SUBMISSION RELATING TO DEVELOPMENT APPLICATION FOR 241-249 WHEAT ROAD, COCKLE BAY

1. This constitutes an objection to the development proposed at 241-249 Wheat Road, Cockle Bay. It is made on behalf of the residents of One Darling Harbour, Pyrmont, who directly face this site.

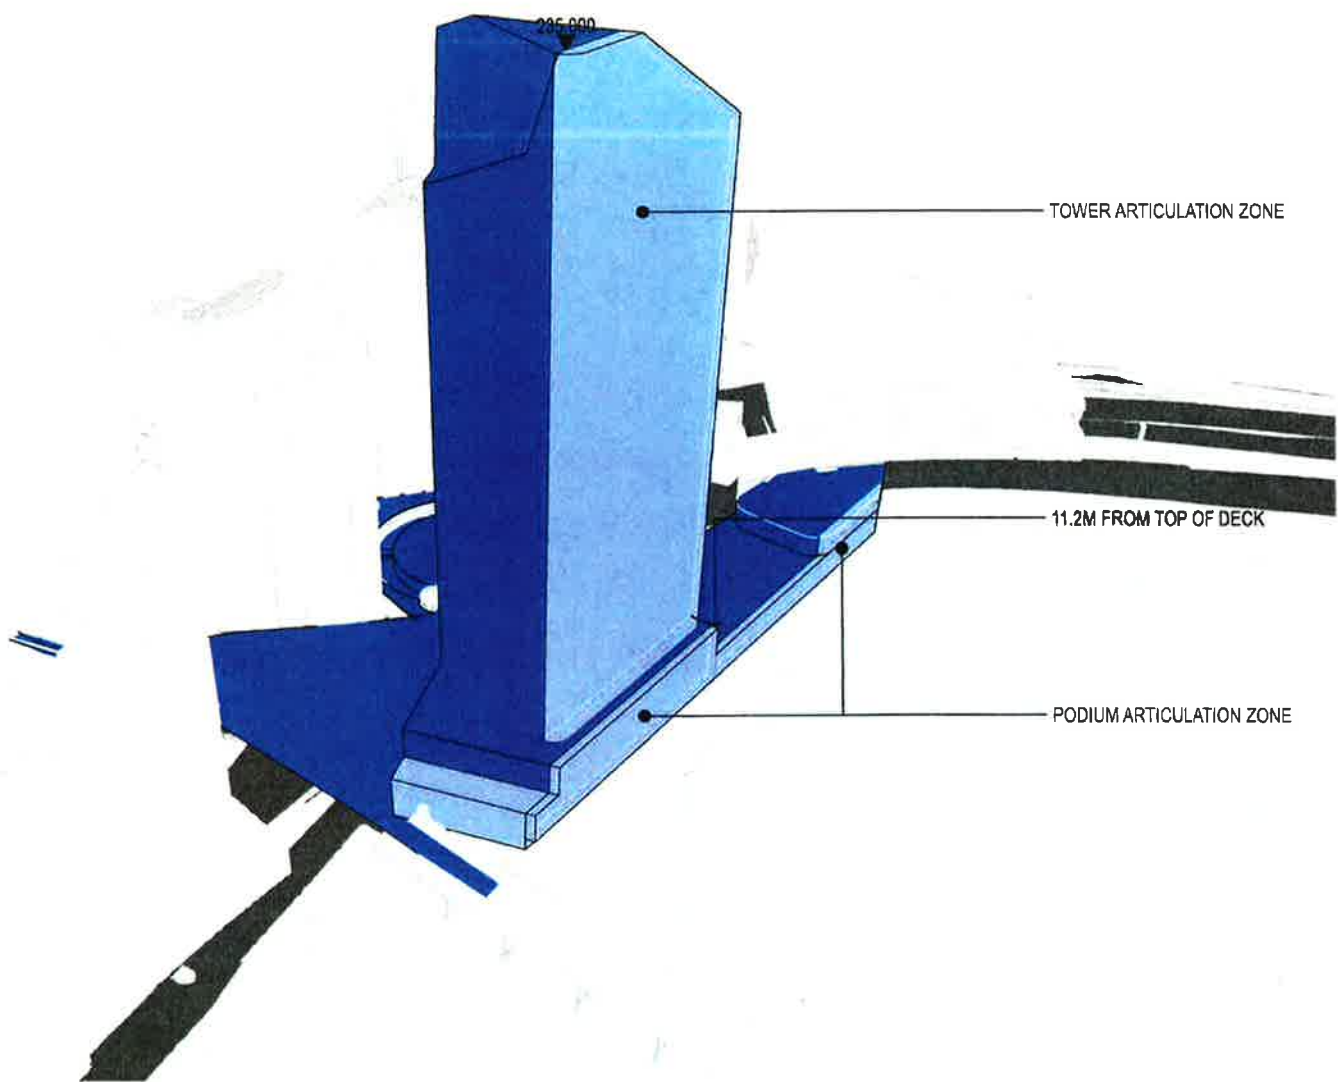
20. Attached as Appendix I are images included in the E.I.S. illustrating the impact of the proposed tower on the context of Pyrmont Bridge. How it can be said that the tower will complement the heritage of the Bridge is difficult to understand.

Building Envelope - 3D View 1

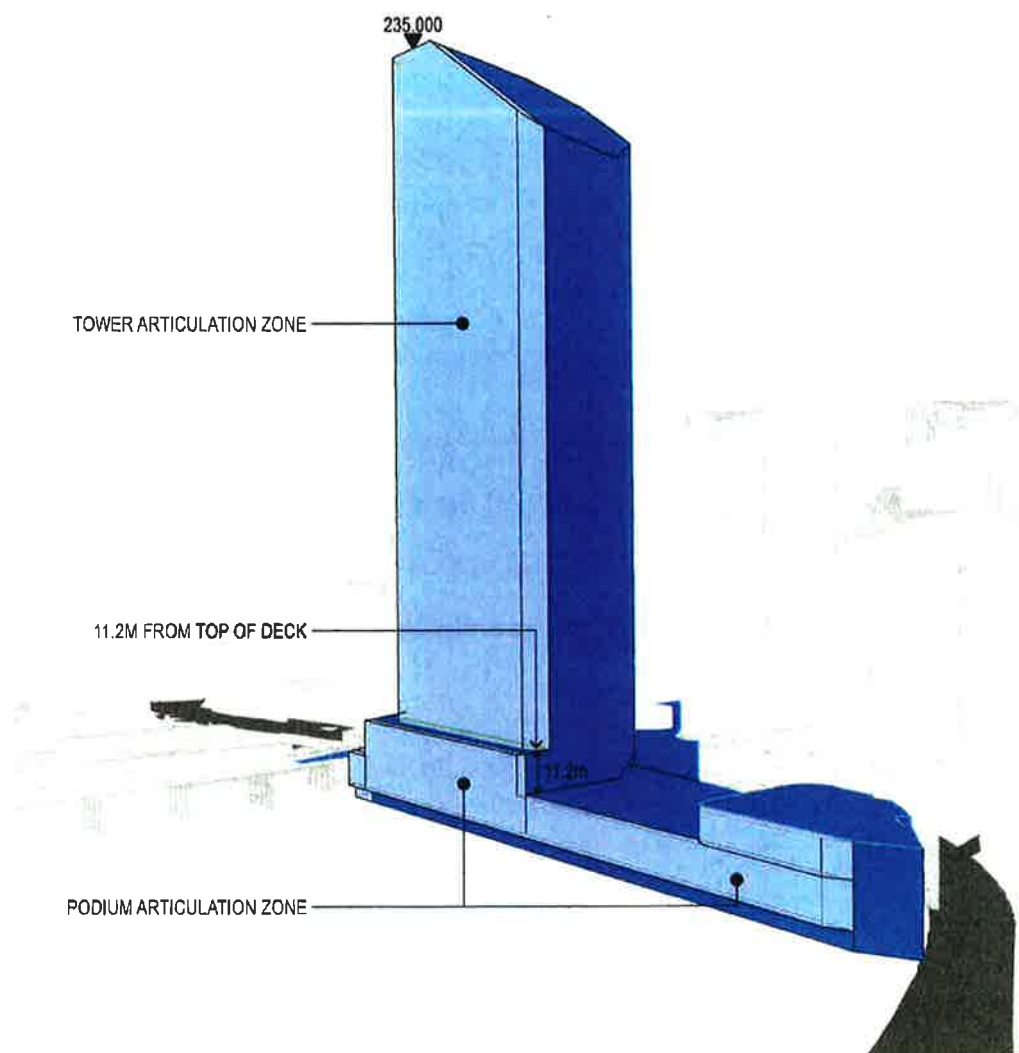
21. Attached as Appendix II are images included in the E.I.S. illustrating the relationship between the tower building and Pyrmont Bridge, together with the relationship with the existing Darling Park buildings and the proximity to the exceptional heritage qualities of Darling Harbour.
